From: Caroline Gosford
Sent: 16 August 2017 15:48
To: Richard Temple
Subject: FW: New Toilet Block, Bognor Prom

From: Paul Cann
Sent: 16 August 2017 15:08
To: Caroline Gosford
Cc: Roger Spencer; Tavis Russell
Subject: New Toilet Block, Bognor Prom

Tavis asked for my comments following receipt of the letter dated 15th August from Southern Water in respect to the above. This is one of their standard letters as you would expect, so they do not appreciate the unique situation at this location.

manhole detail

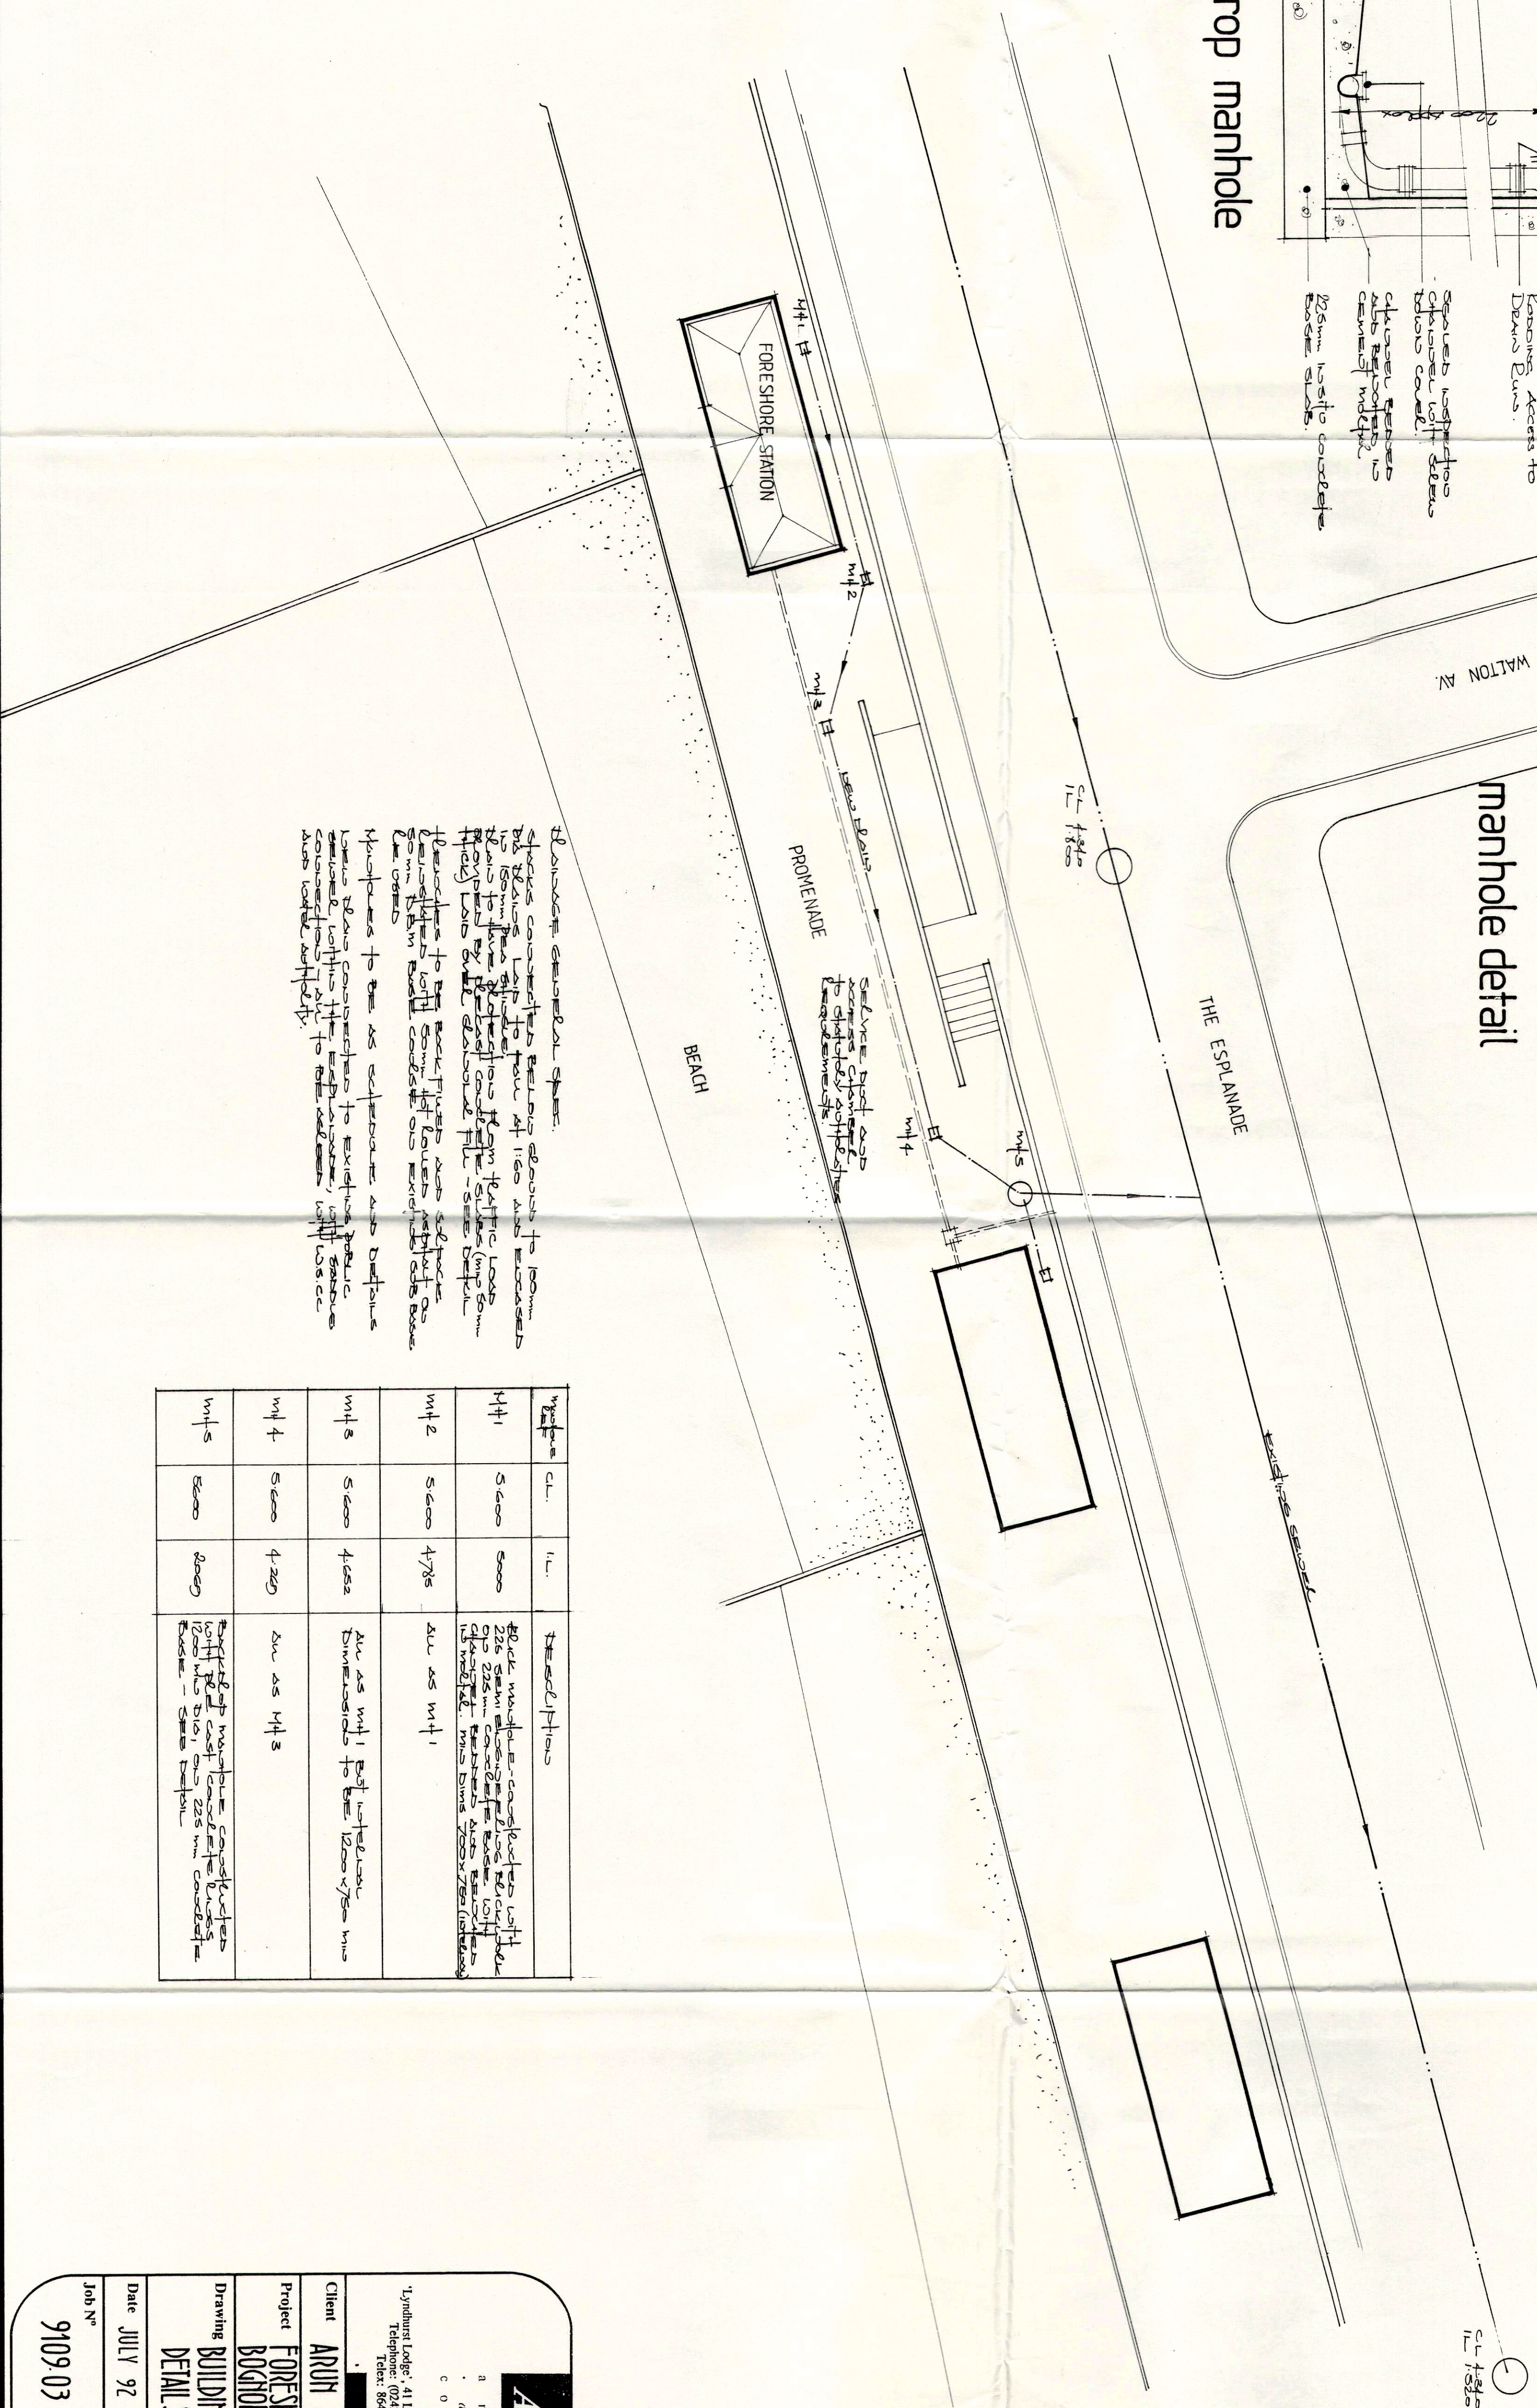
We also believe Southern Waters sewer records are not correct, in particular the 600mm diameter rising main which is shown partly to run under the prom. Roger is 100% certain that it is entirely contained within the road. The 675mm diameter public surface water sewer is also noted to be running along the south side of the road. Roger is on site tomorrow (looking at the bandstand) so he will relook at the lie of the land then.

Bearing in mind, there is a significant sea/prom wall between the road edge and the proposed toilets, there will be no detrimental effect on their apparatus and the proposals will not increase their future maintenance liabilities, even if the pipelines were within 4 metres of the new building.

Any possible imposed loadings emanating from the building will be intercepted by the rear sea wall, and therefore not transferred onto their pipelines. If they ever had to repair/replace either pipeline then the wall would be left in situ and not disturbed, and therefore the building would not hinder future access/repair.
